Appeal Decision

Appeal Ref: APP/R5510/W/18/3215432

Grove Bay, Grove Lane, Hillingdon, Middlesex, UB8 3RG

- The appeal is made under section 78 of the Town and Country Planning Act 1990 against a refusal to grant planning permission.
 - The appeal is made by Mr C Gill against the decision of the Council of the London Borough of Hillingdon.
 - The application Ref 73172/APP/2018/992, dated 12 March 2018, was refused by notice dated 21 May 2018.
 - The development proposed is 2 x two and a half storey, 4-bed semi-detached dwellings, with associated parking and installation of vehicular crossovers, involving demolition of existing dwelling.
-

Drawing: **PROPOSED SITE PLAN.**

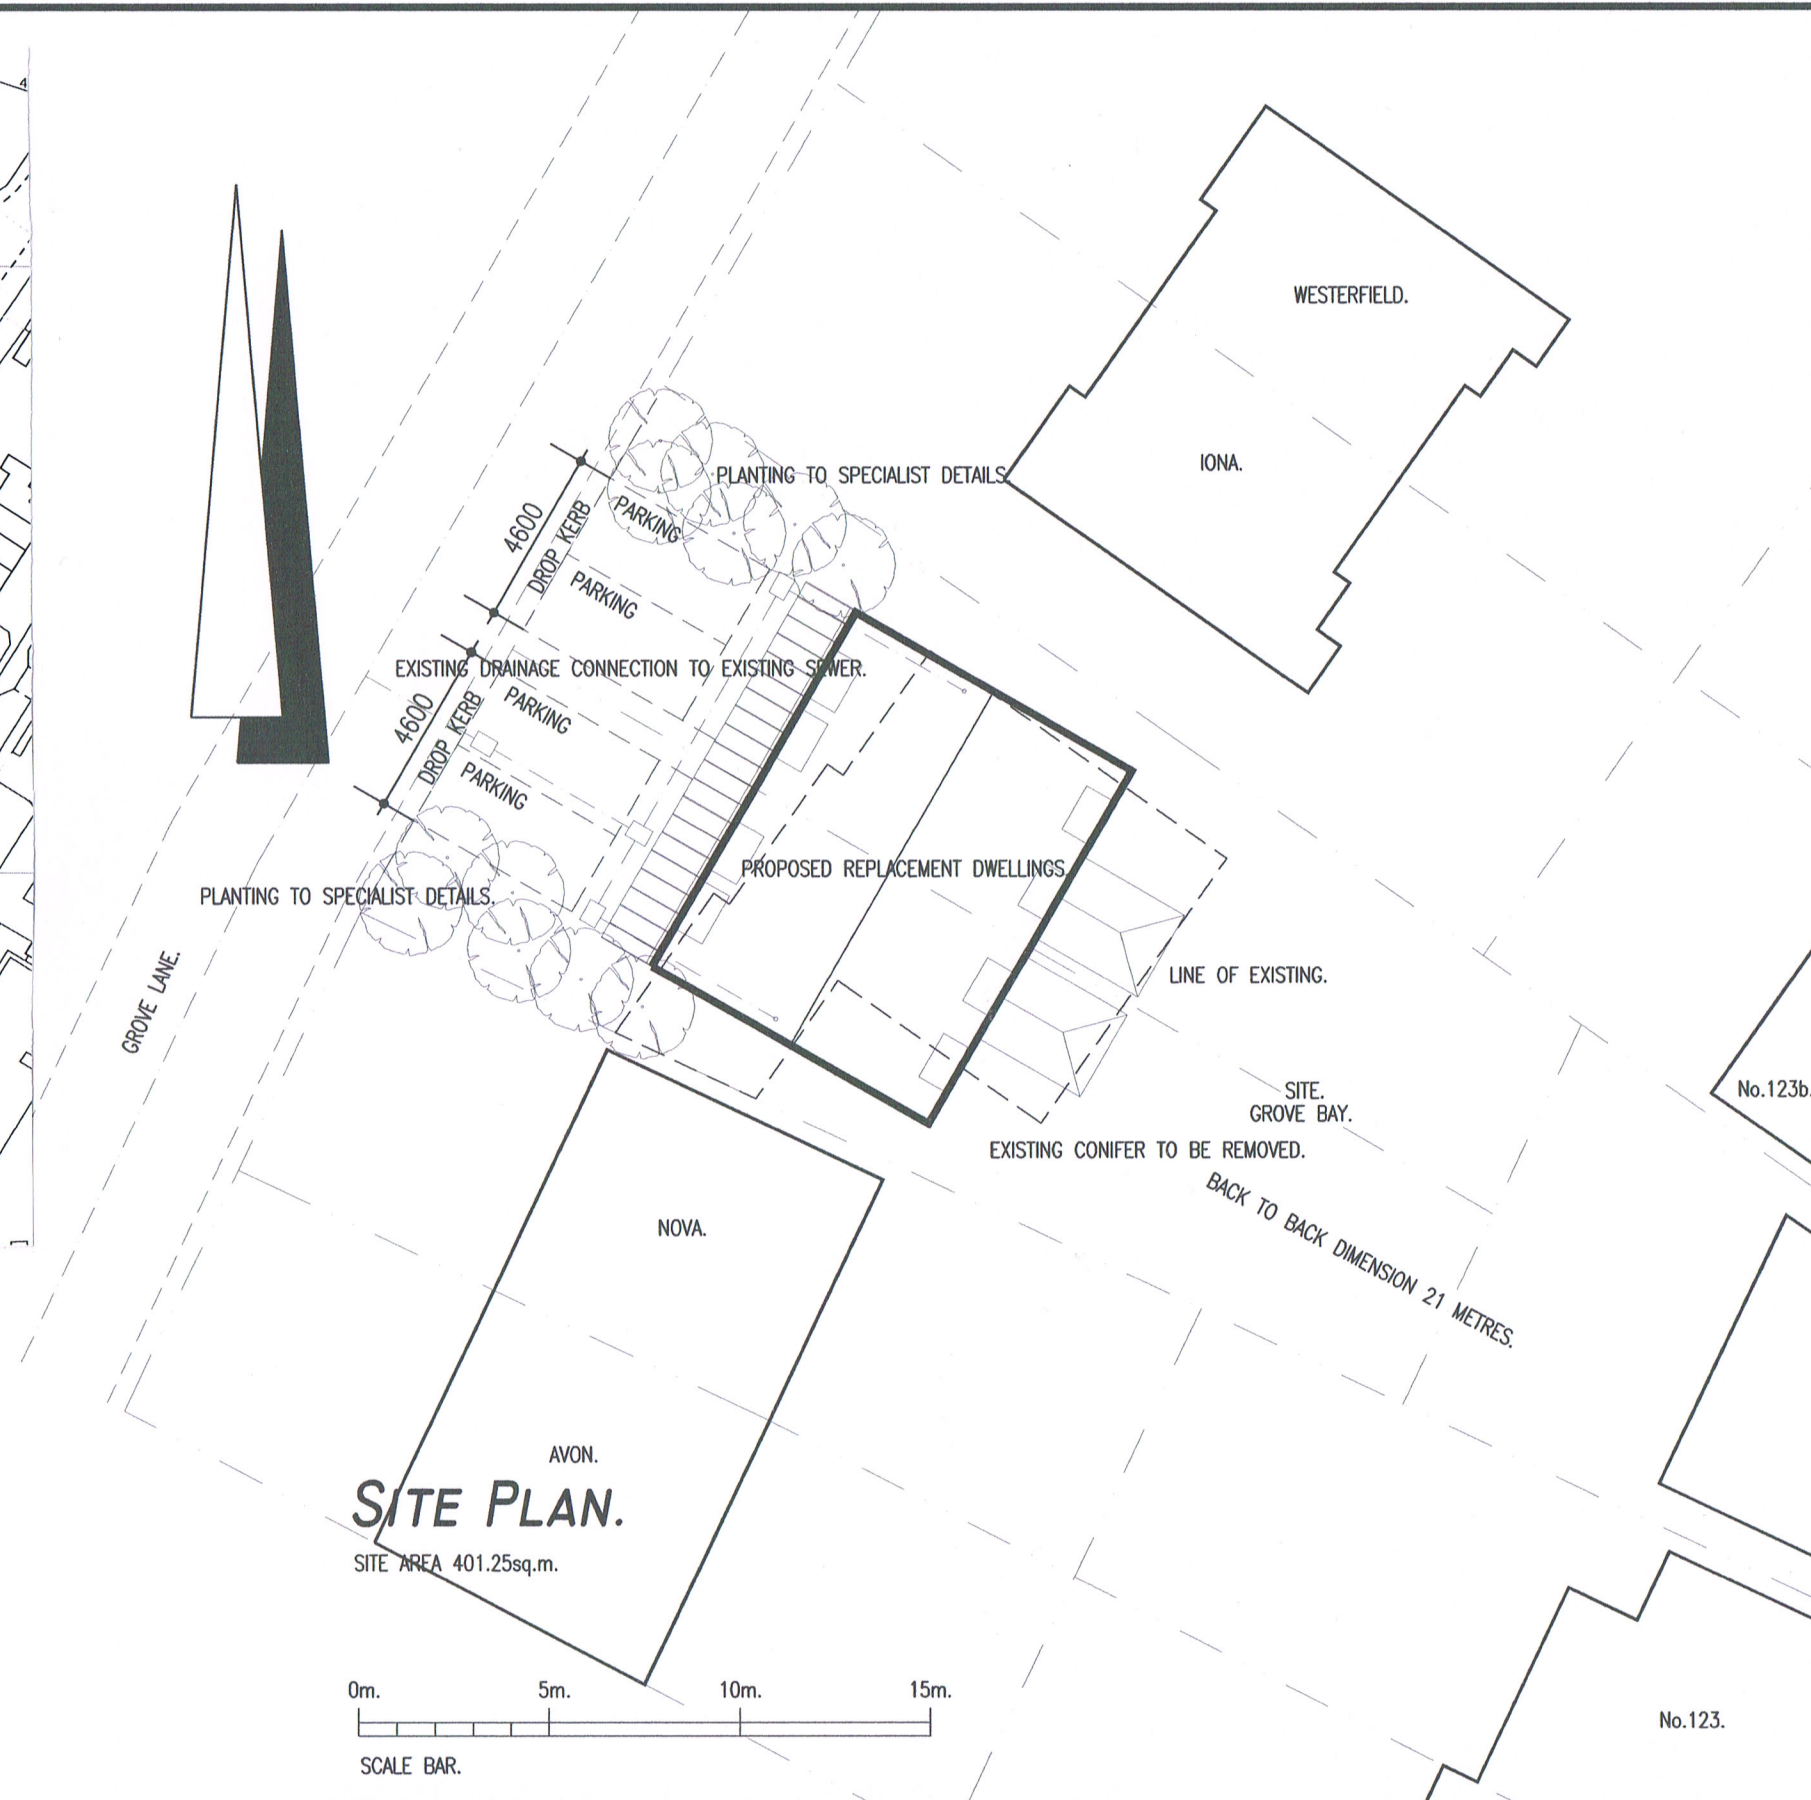
6. The proposal is for the replacement of the existing bungalow with a pair of semi-detached 2 and a half storey townhouses. The proposal seeks to reflect the existing building line and proposes materials the appellant considers to be broadly consistent with the area. It also would be set off the boundaries by an acceptable amount such that it would accord with policy BE22 of the Hillingdon Local Plan: Part Two (2012). However, the height and tall proportions of the proposed townhouses would appear at odds with the local character. Despite their domestic design they do not respect the particular scale of the street. Whilst there is some change in heights between the bungalows and 2 storey dwellings locally, a building with an additional half storey as proposed would have a dominant and detrimental impact on the character and appearance of the area. This would be exacerbated by its positioning slightly forward and at an angle to the neighbouring properties to the north.

7. The proposal would therefore have a harmful effect on the character and appearance of the area due to its height, scale and positioning. Consequently it would be contrary to Policy BE1 of the Hillingdon Local Plan: Part One - Strategic Policies (2012), saved policies BE13 and BE19 of the Hillingdon Local Plan: Part Two (2012), policies 7.1 and 7.4 of the London Plan (2016), the Mayor of London's adopted Supplementary Planning Guidance (SPG) - Housing (2016), the adopted Hillingdon Design and Accessibility Statement (HDAS) Supplementary Planning Document (SPD): Residential Layouts and paragraph 130 of the National Planning Policy Framework (2018). Taken together, these require new development to be of a high quality design, to harmonise with the existing area and help reinforce the character of the neighbourhood.

8. The adopted *HDAS SPD* sets a minimum guideline for gardens of 4 bedroom properties of 100 square metres (SqM). There is some disagreement regarding the exact measurements of the gardens proposed. However, even if I was to accept the appellant's larger figure of approximately 80SqM (when not including the proposed conservatories or space to the side of the dwellings which don't contribute to the useable garden area) this is substantially below the minimum figure. Also, given the existing tall mature landscaping within the garden and height of the building proposed, the garden areas feel enclosed. Whilst allowing for personal preferences of future occupiers and availability of open space in the wider locality, I nonetheless consider that the usable private space to be enjoyed by future residents would not be of sufficient size or quality.

9. Therefore the proposal would not provide satisfactory living conditions for future occupiers in respect of outdoor amenity space. Consequently, the proposed development would conflict with saved policies BE23 and BE19 of the Hillingdon Local Plan: Part Two (2012), London Plan Policy 3.5 and the Council's SPD which, in combination, seek to ensure that new dwellings provide external amenity space which is sufficient to protect the amenity of future occupants.
